APPLICATION NO. <u>06DRB00110</u>	PROJECT NO. <u>1004665</u>
PROJECT NAME <u>SANDIA SCIENCE &amp; TECHNOLOGY PARK</u>	
APPLICANT / AGENT <u>DCSW</u>	PHONE NO. <u>843.9639</u>
ZONE ATLAS PAGE <u>M. 21</u>	DATE SUBMITTED <u>1-26-06</u>

February 9, 2006

RE: COMMENTS ON SANDIA NATIONAL LABS OFFICE BUILDING  
SANDIA SCIENCE & TECHNOLOGY PARK

SHEET TITLE
OVERALL BUILDING ELEVATIONS

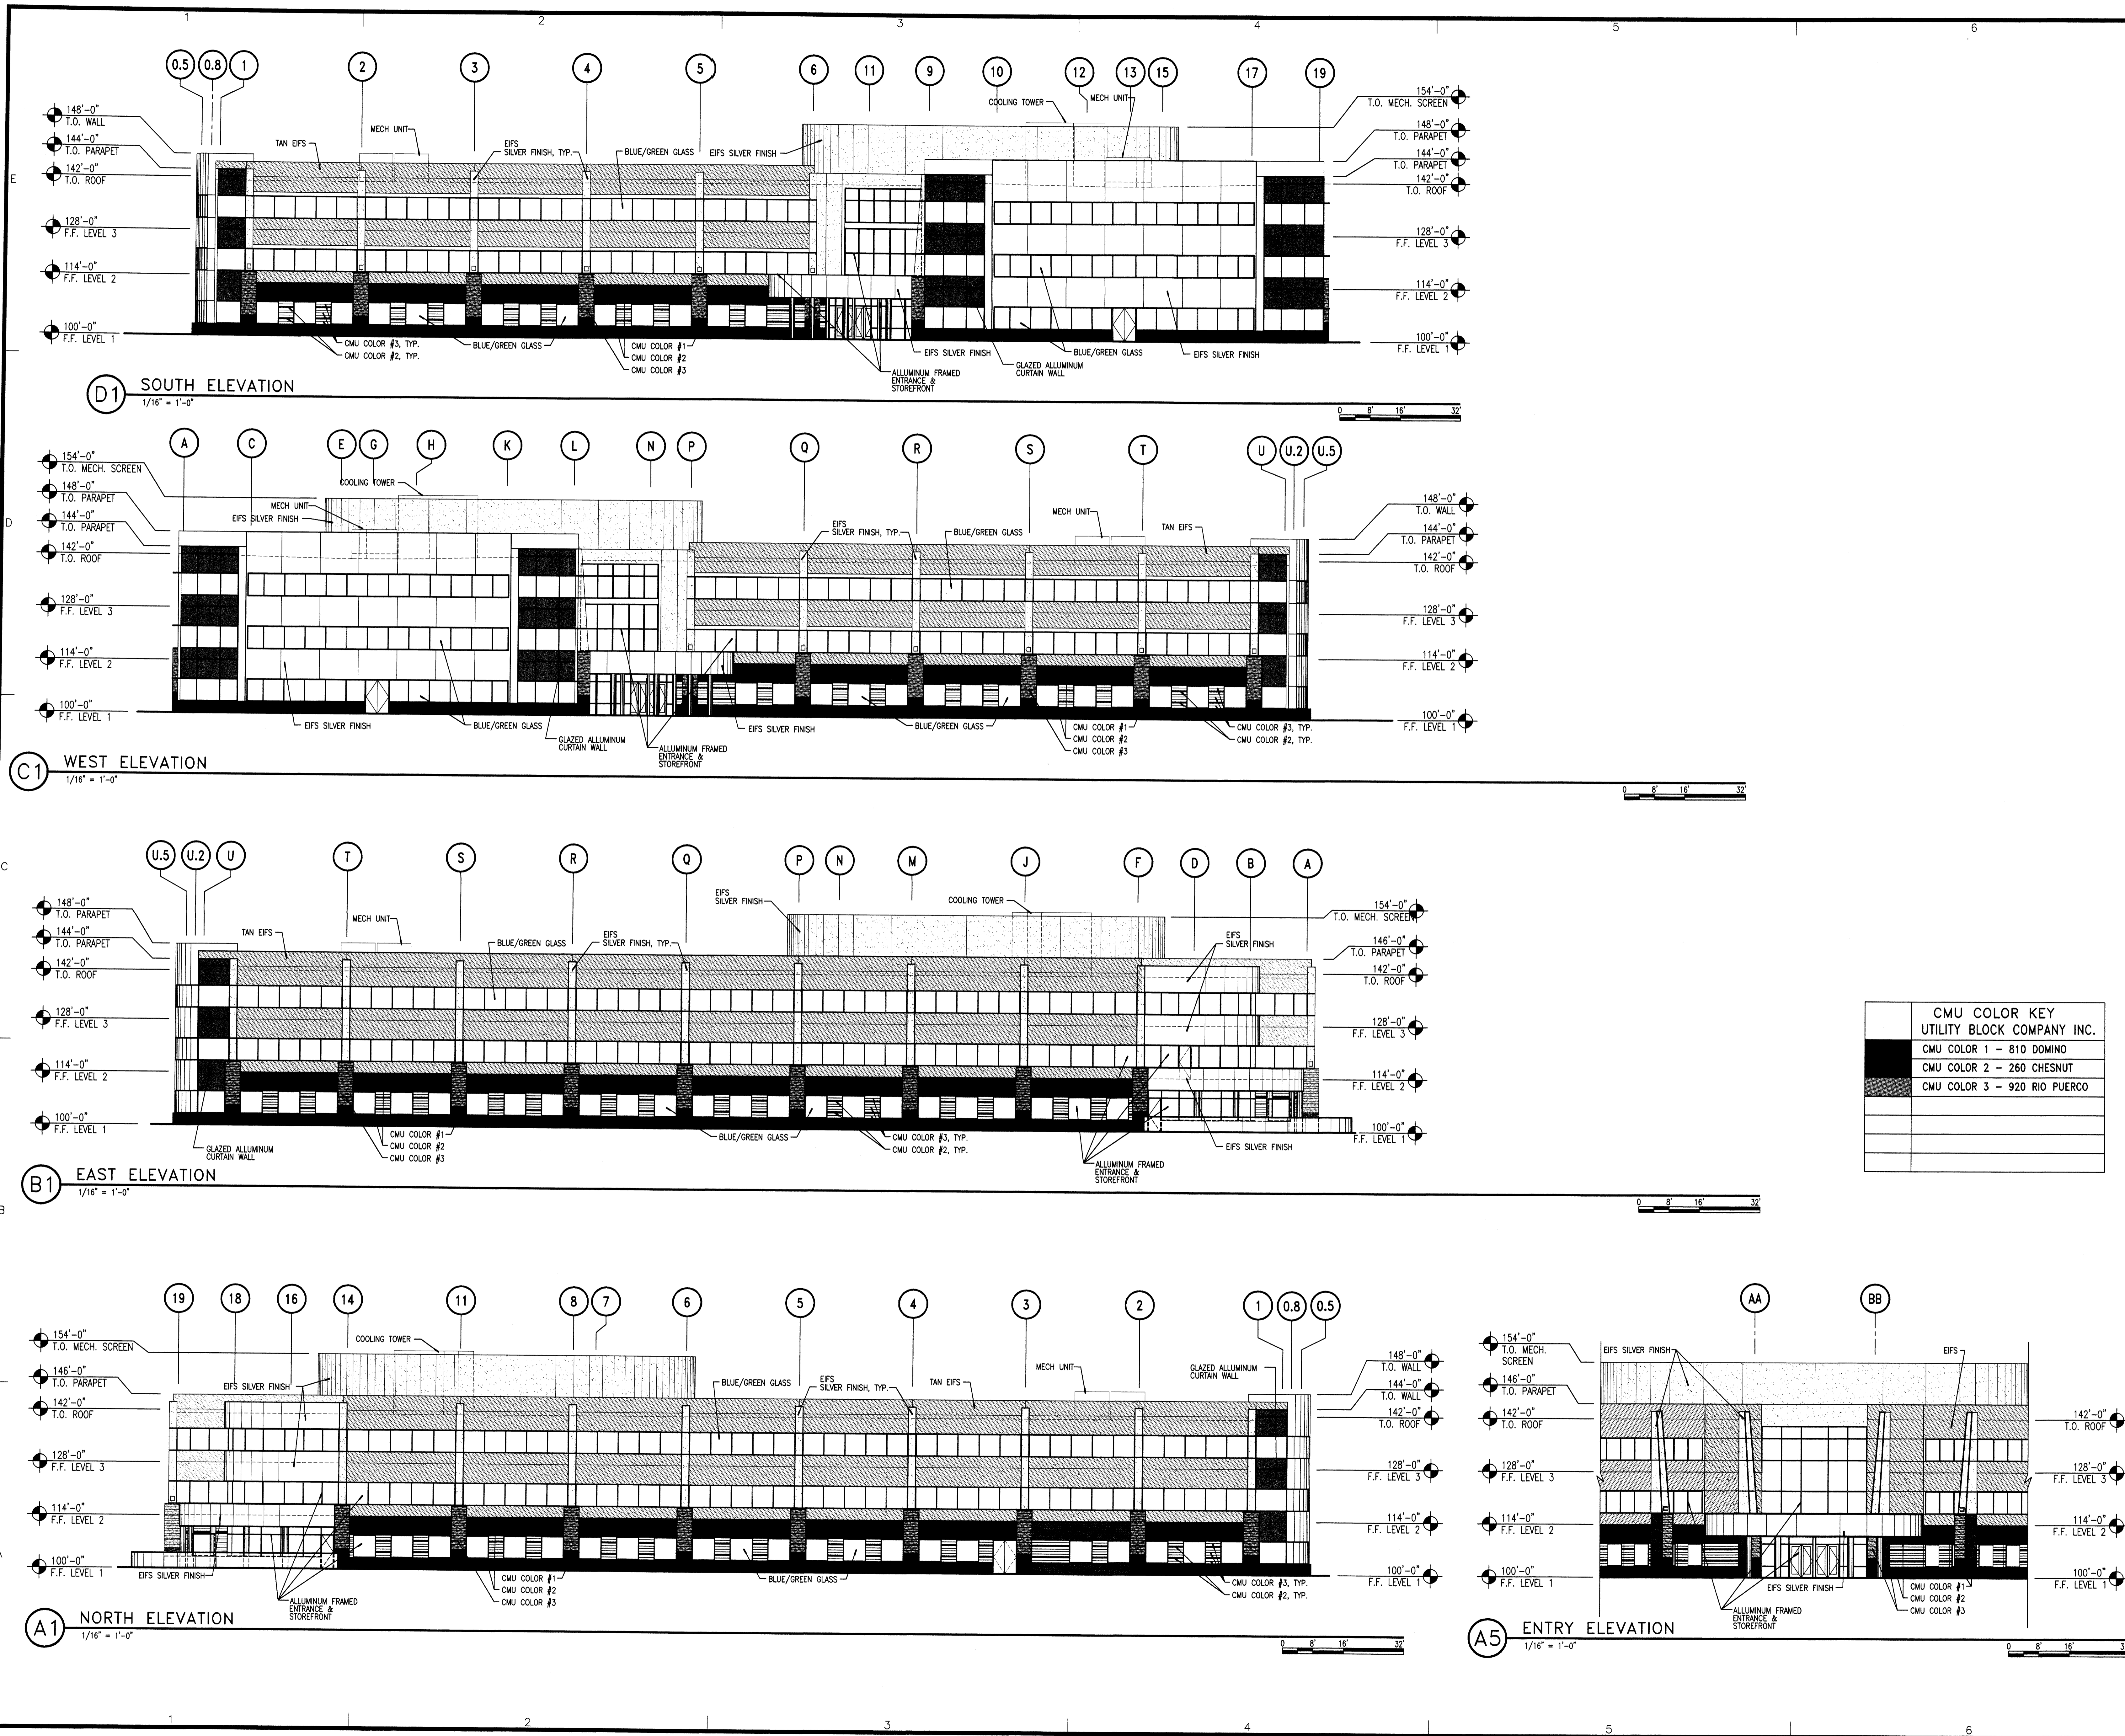
5. The Journal Center is working with the City to decrease the amount of high water use plants they are including in new development. SS & TP should avoid the use of high water use plants as well. Please re-look at the landscaping plan to see where water use can be further reduced.
6. Solid Waste should sign off on the site plan sheet. Please have them do so.
7. The total width of the building is missing as a dimension on the building Elevations sheet.
8. The sign colors are missing from the elevation.
